Tuck O'Brien  
City Planning Director, Planning Division

Project Name: **Conversion of Sala Thai to Taco Bell with drive-through**  
Project ID: #2016-007  
Address: 1363 Washington Avenue, Portland CBL: 401 A002001  
Applicant: Guggenheim Retail Real Estate Partners, Inc.  
Planner: Jean Fraser

On May 13, 2016, the Planning Authority approved with conditions a Level II site plan for the conversion of the existing Sala Thai restaurant (with no drive through) to a Taco Bell restaurant with a drive through at 1363 Washington Avenue.

EXTERIOR ELEVATIONS

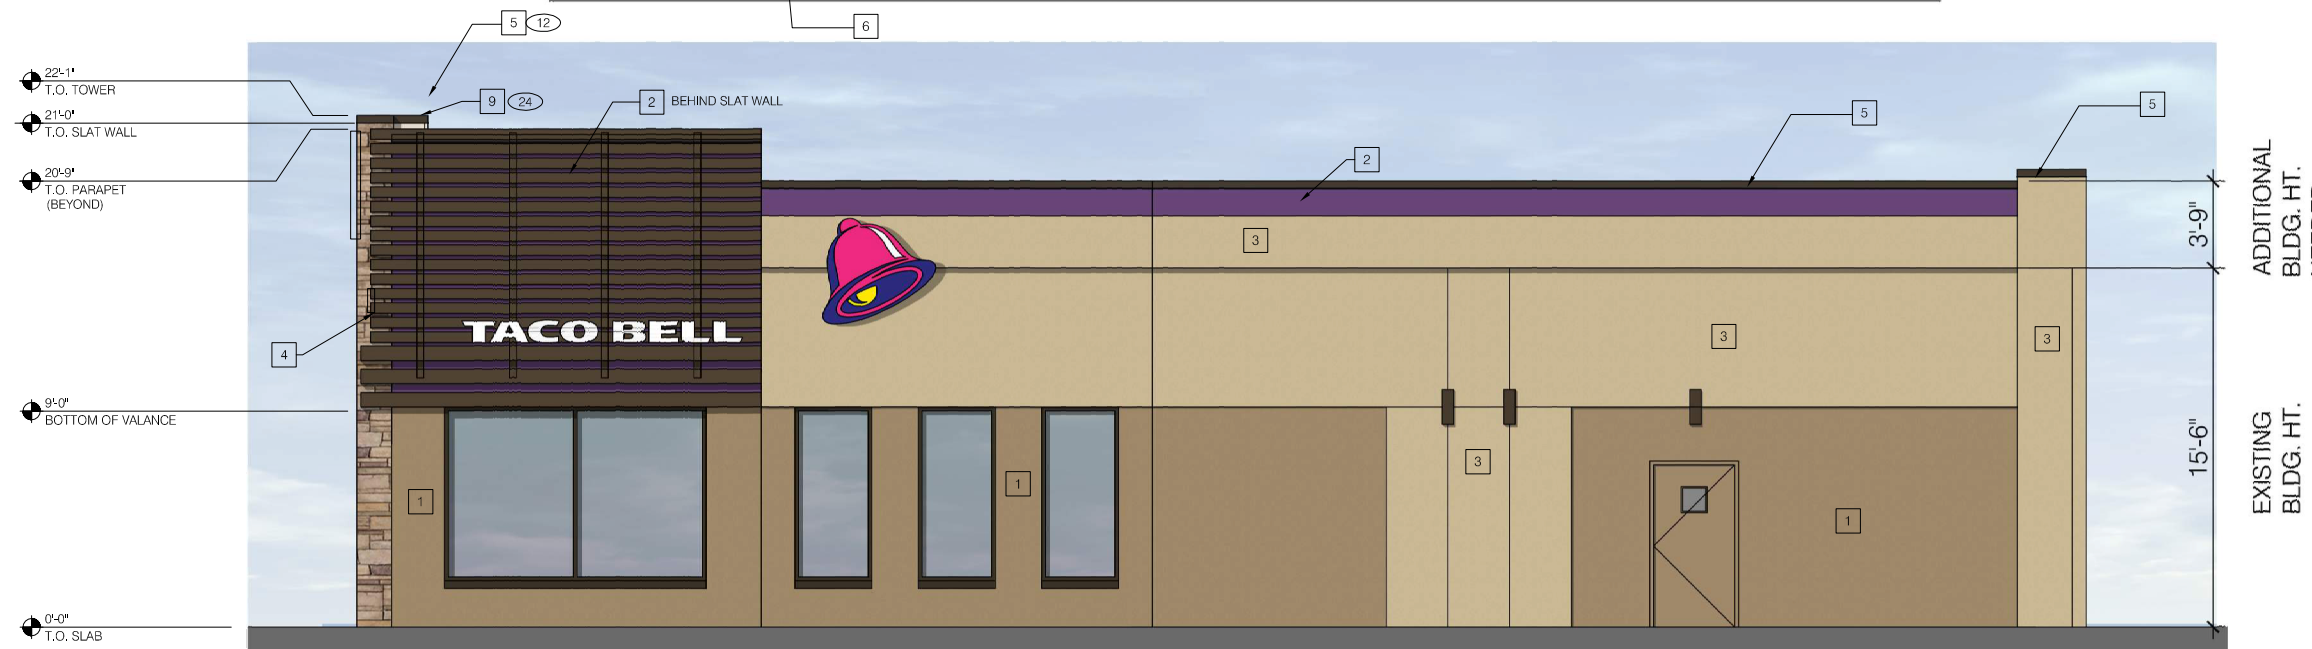
- iv. The project was reviewed to confirm conformance with the B2 Design Standards and the attached (undated) elevation has been approved, based on the understanding that any new windows will be specified to be Solarban 60 Starphire Ultra-Clear Glass (or equivalent) of a tint to match the tint of the existing windows; and

**C-2**

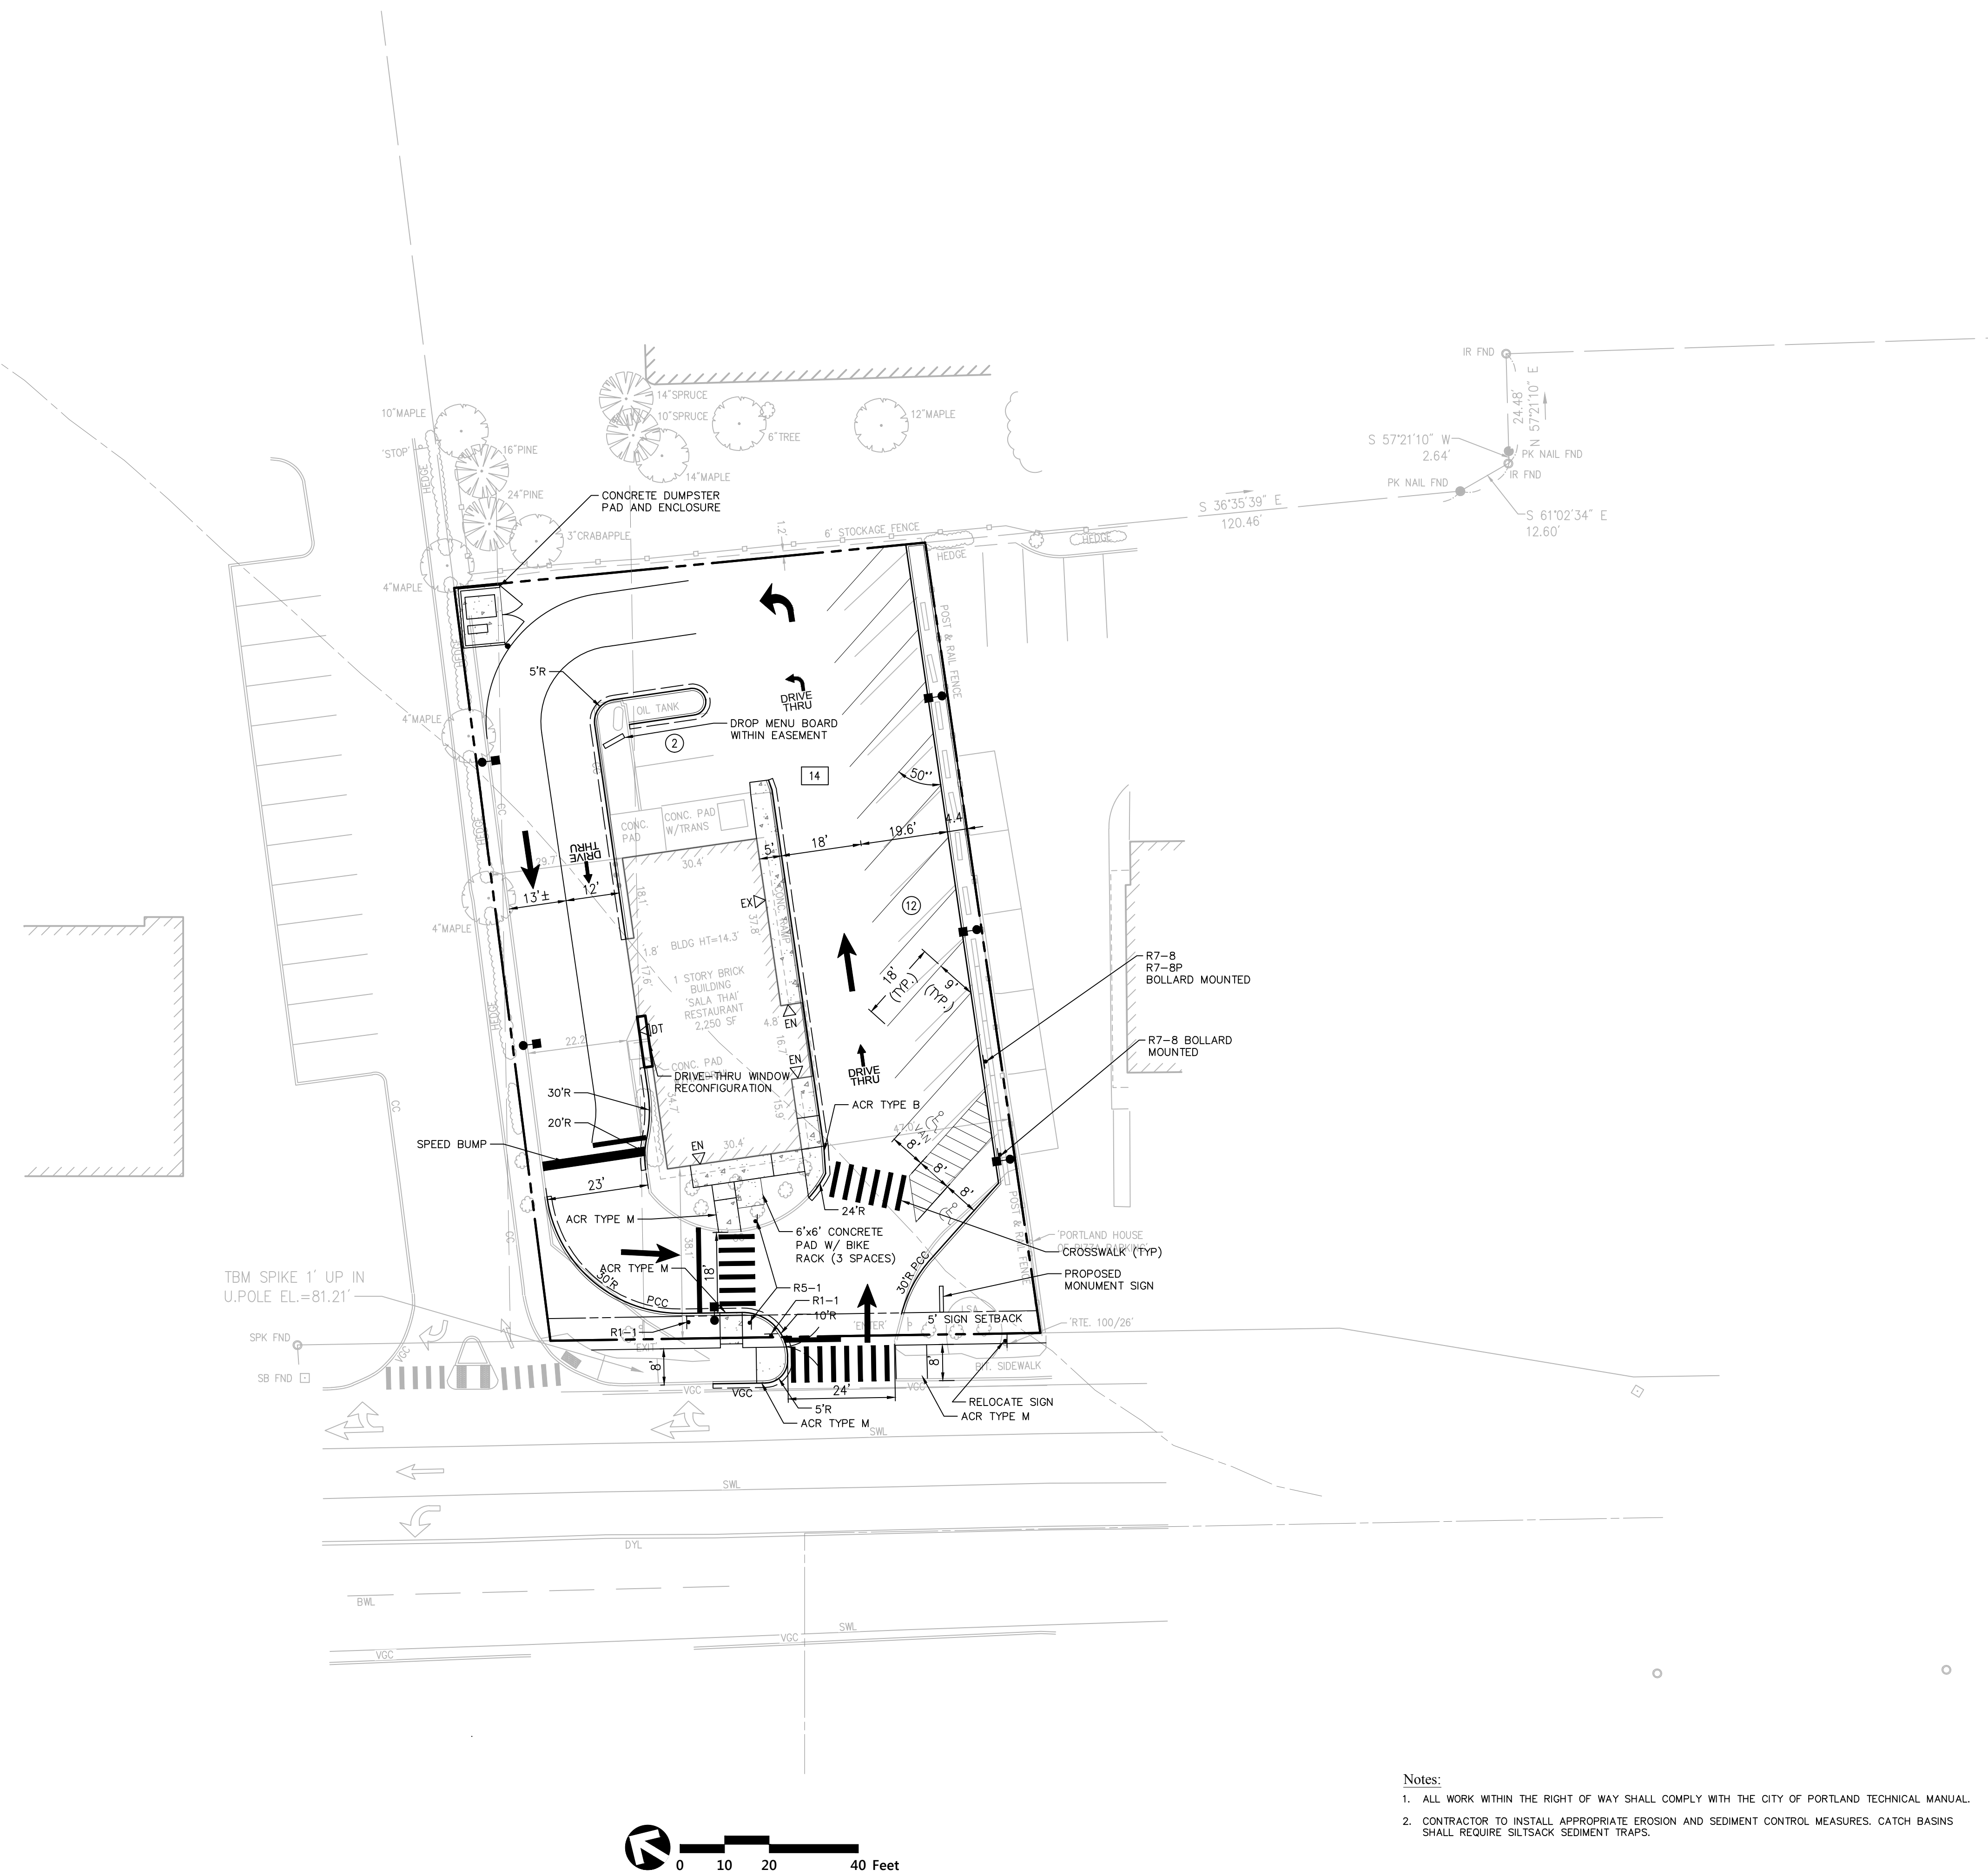
The Planning Authority waives the Technical Standard, Section 1.14 and associated figures, which specify aisle widths and parking space dimensions, to allow the parking lot layout to be based on 50 degree angled parking as shown on the approved Layout Plan.
